From: [REDACTED]
Sent: 01 February 2023 12:00
To: Planning
Subject: FAC [REDACTED]

Ref: Land to rear of Malt Kiln House, Malt Kiln Brow, Chipping, PR3 2GP

From: [REDACTED]
Sent: 02 February 2023 20:23
To: Planning
Subject: Application number 3/2022/0568. Land to the rear of Malt Kiln Brow.

Planning Application Reference No.: 3/2022/0568

| Traffic Management Plan. | | | | |

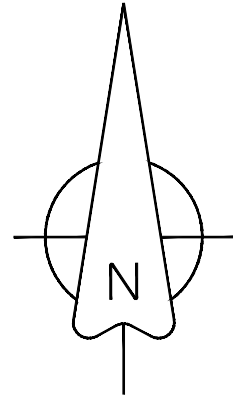
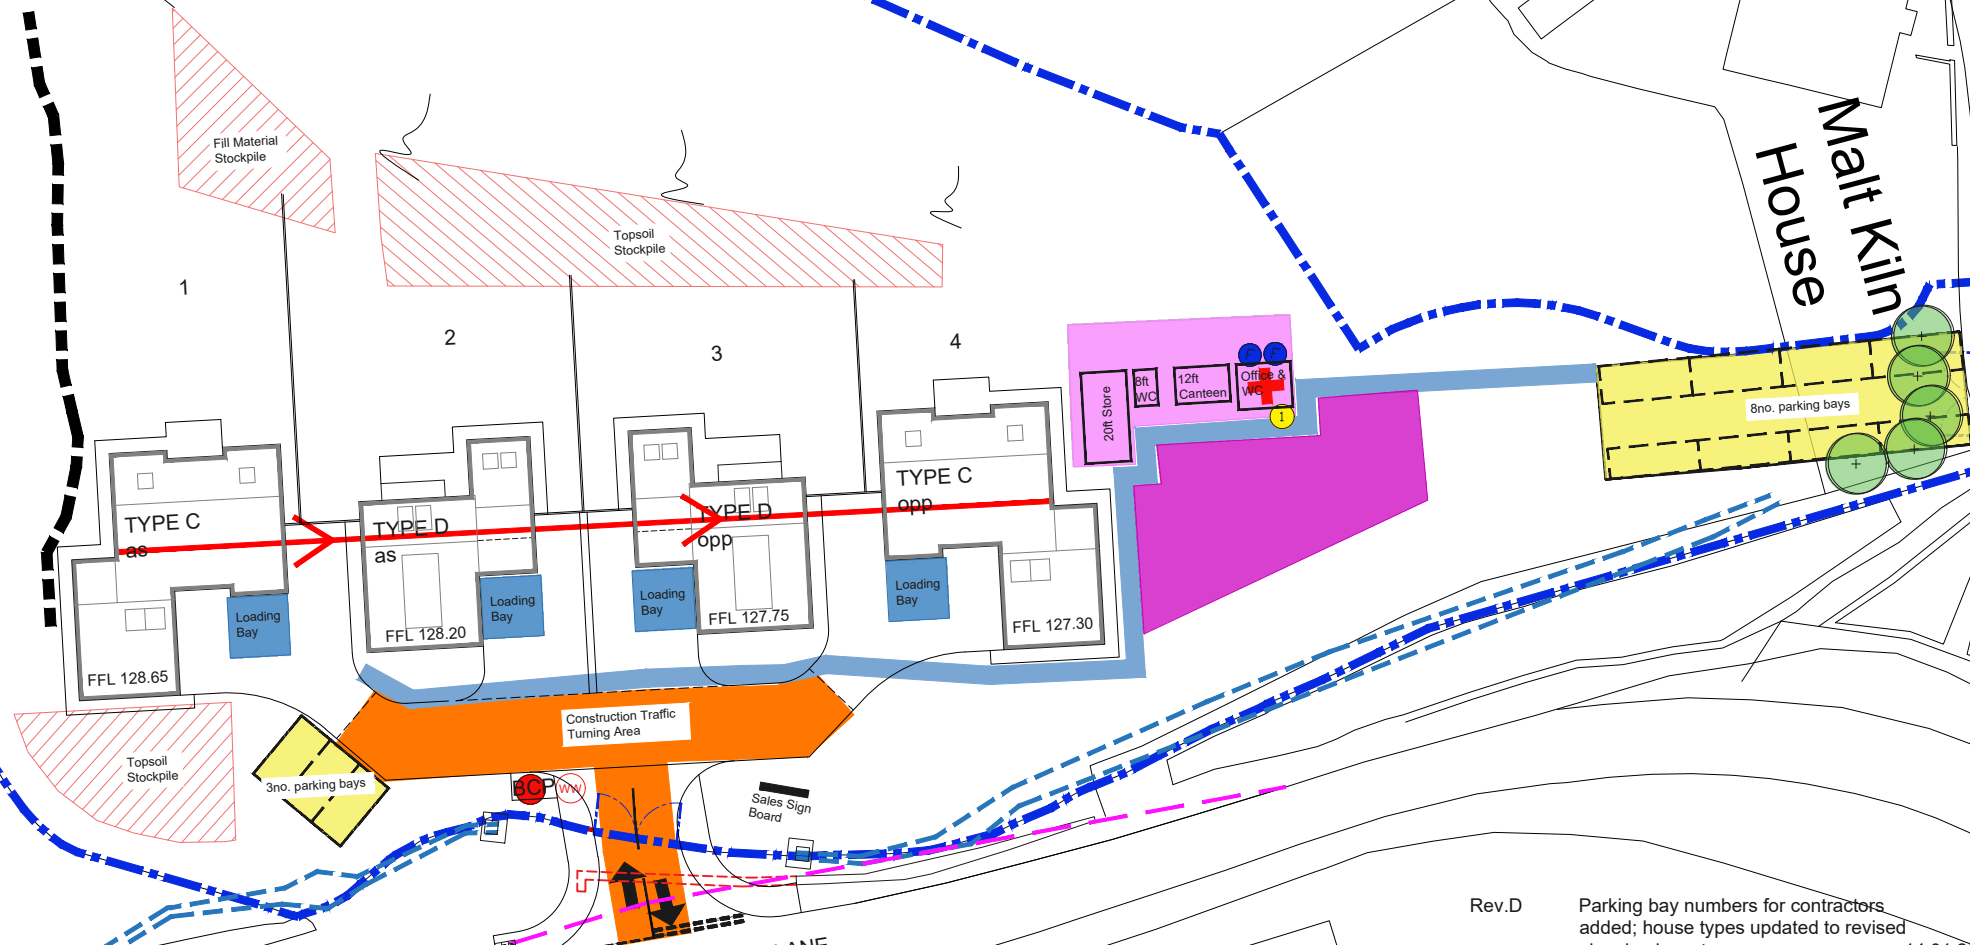
10 During the long drawn out build of the Fellside development the people of this development were subjected to abuse by builders/contractors who parked on roads and across driveways of home owners. The proposed traffic management plan does not seem to have adequate parking so it is very likely that these problems will reoccur.

PROJECT Proposed Residential Development at Church Rake, Chipping.				
DRAWING TITLE Hard Landscaping, Soft Landscaping & Boundary Treatment Layout.				
DATE June 2022	SCALE 1:250 @ A1	DRAWN SAH	DRWING NO. LAN/BN/P01	REV

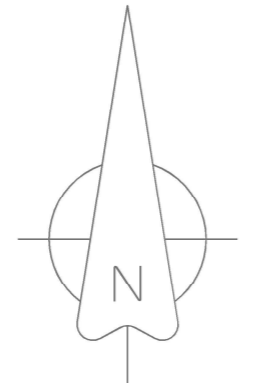
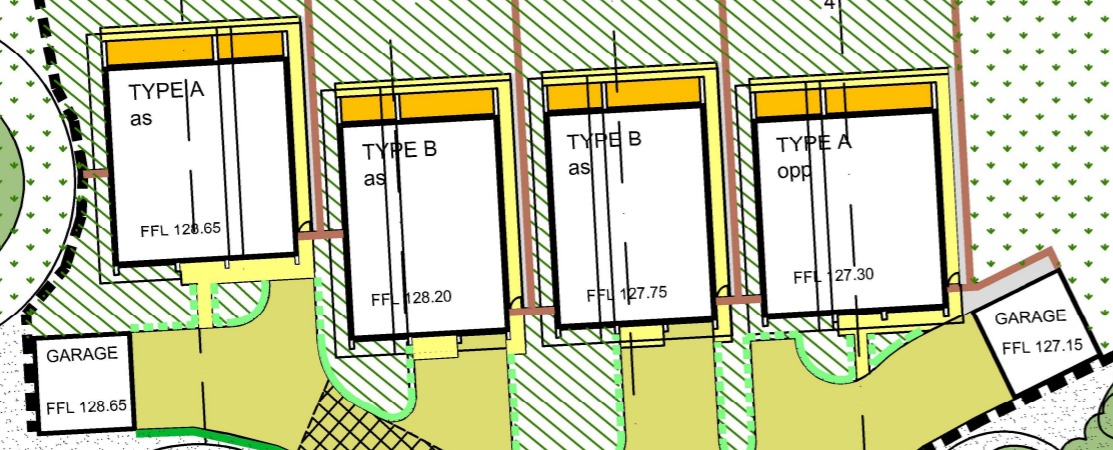
4. The hard and soft landscaping drawing shows most of the site outside the house gardens designated as "Rough grassland to be retained" but much of this rough grassland has been destroyed. Will it be reinstated

then reseeded with an ecologically friendly seed mix? It should be as this would be best for the environment. Gradually we will probably see 'pioneer' shrub and tree species colonising the ground. Without grazing animals to nibble seedlings this could help reinstate what has been lost.

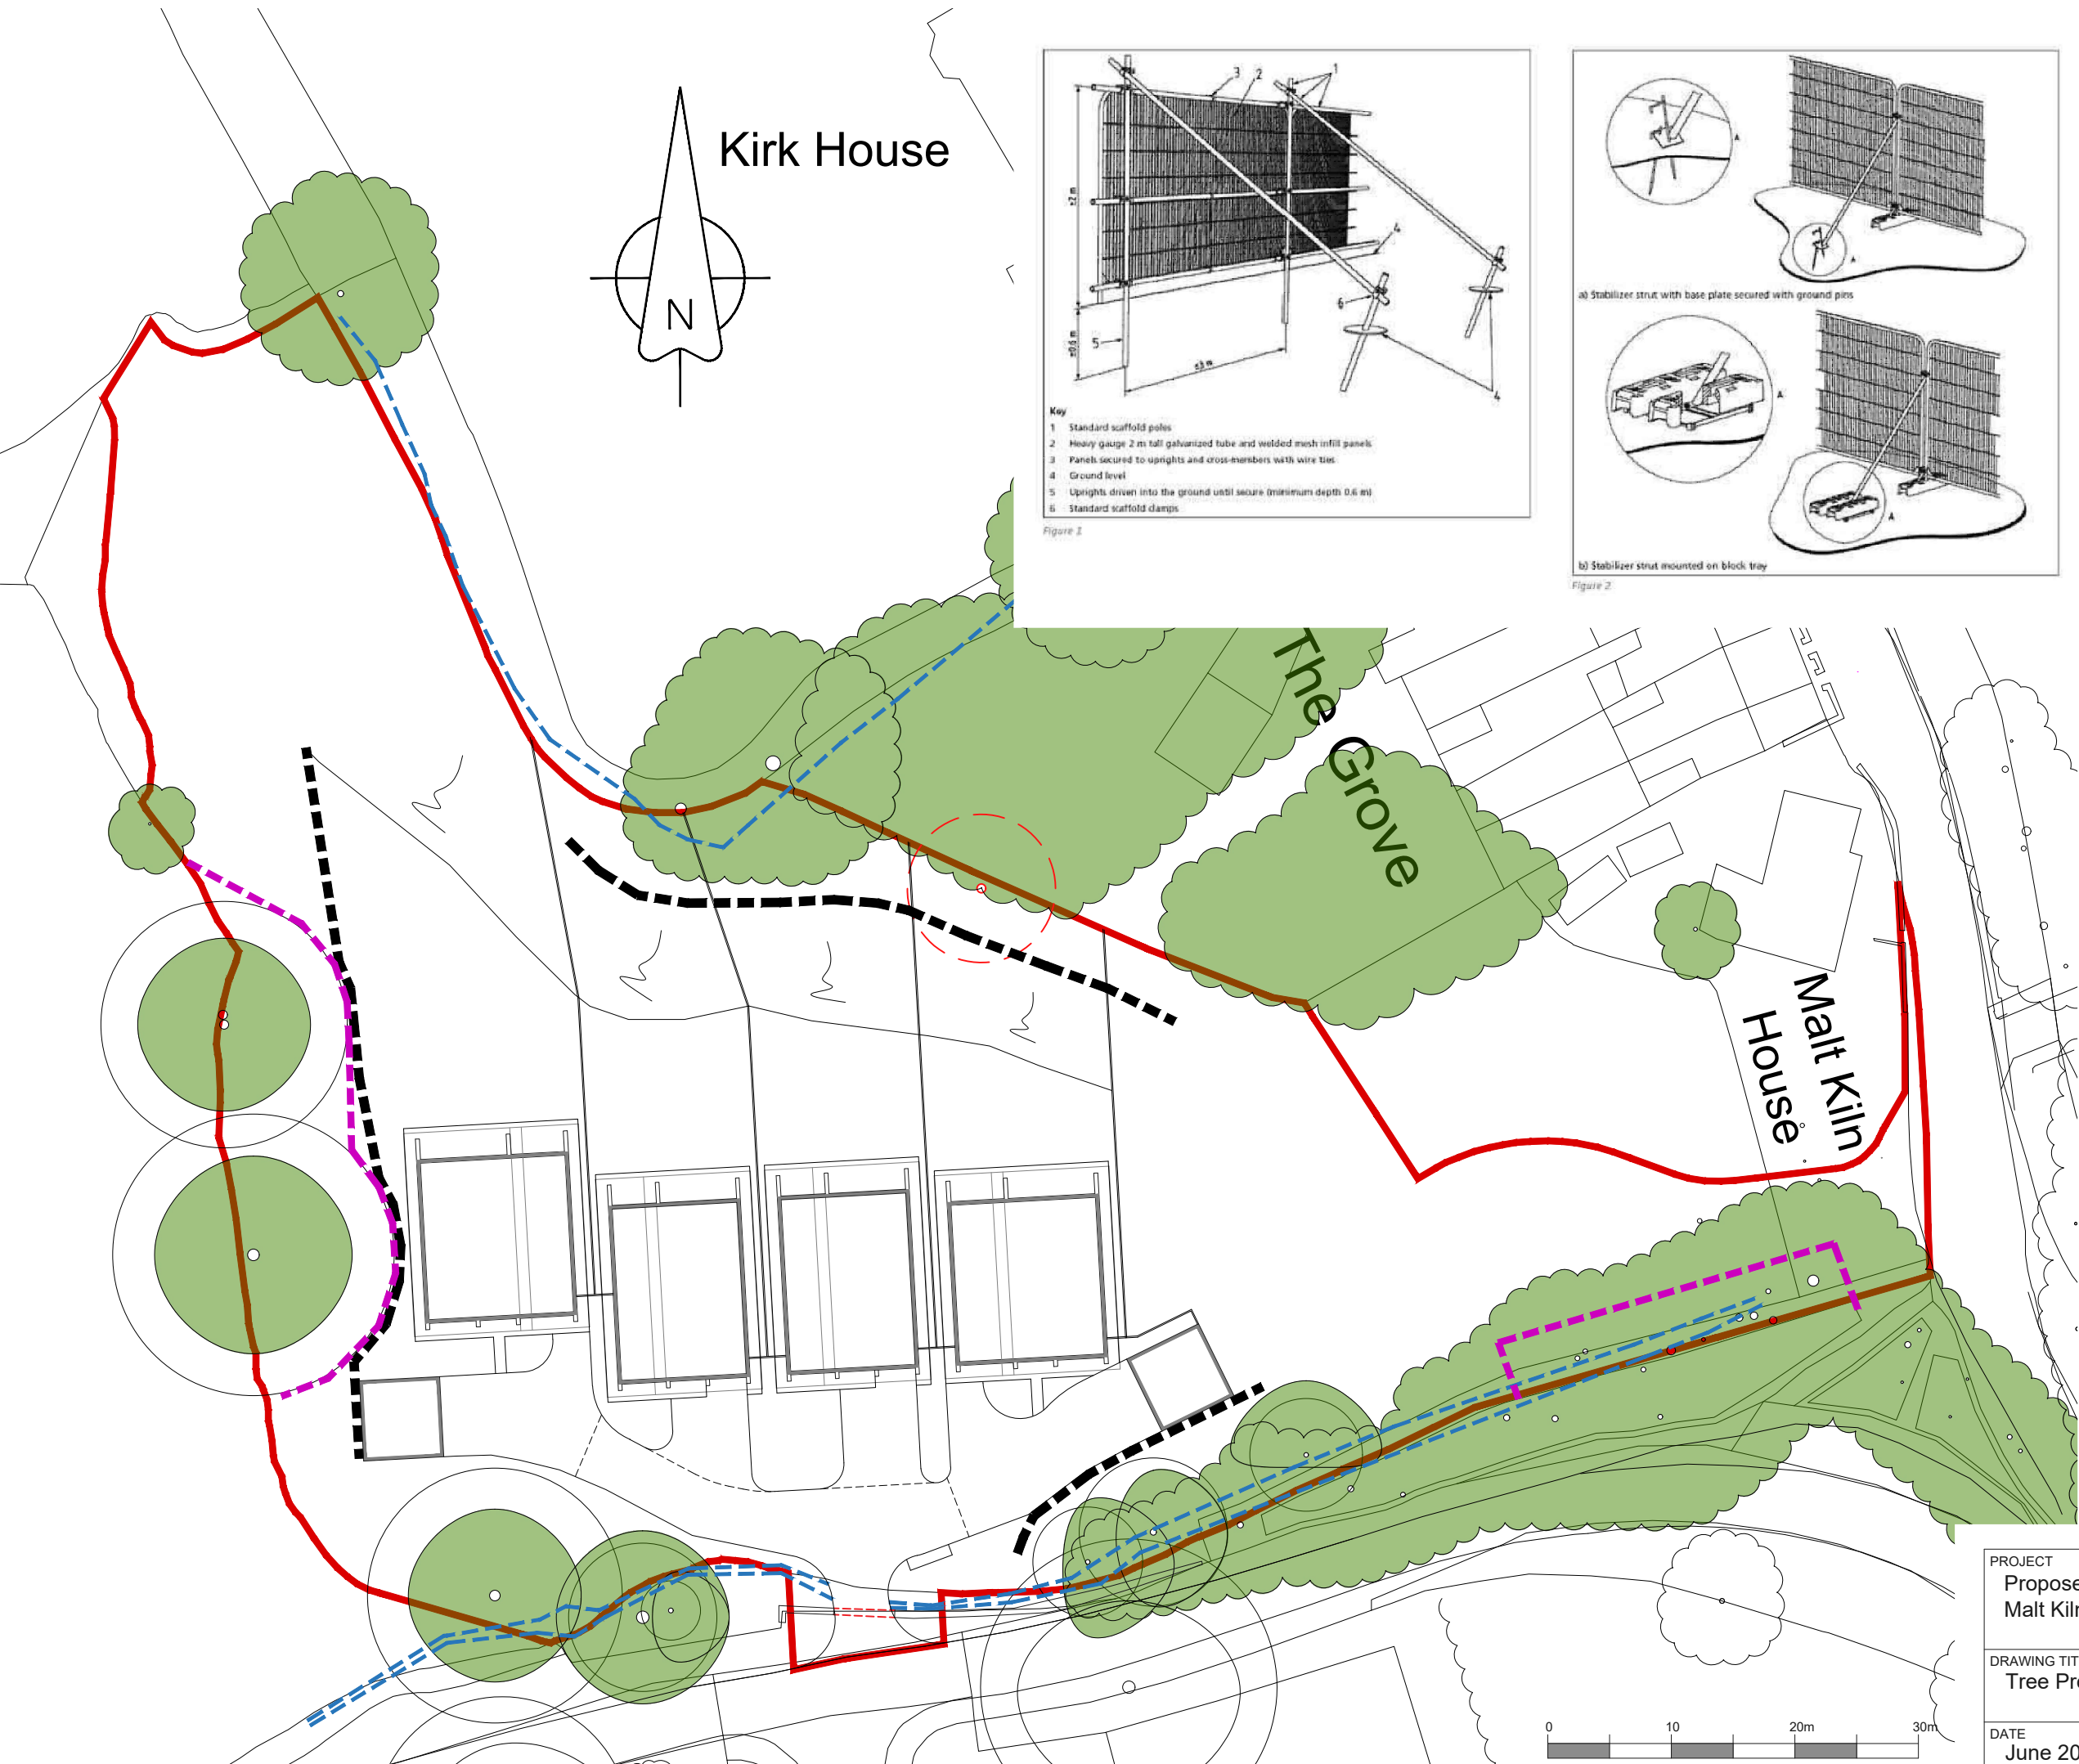
1. The retaining wall on the western boundary is shown right on the edge of the Root Protection Area (RPA) of tree T9 and T8, but you can't actually build the wall in that position without making a serious impingement on the RPA of both trees. The risk here is that these large mature trees, both rated 'good' in the tree survey will be seriously damaged.
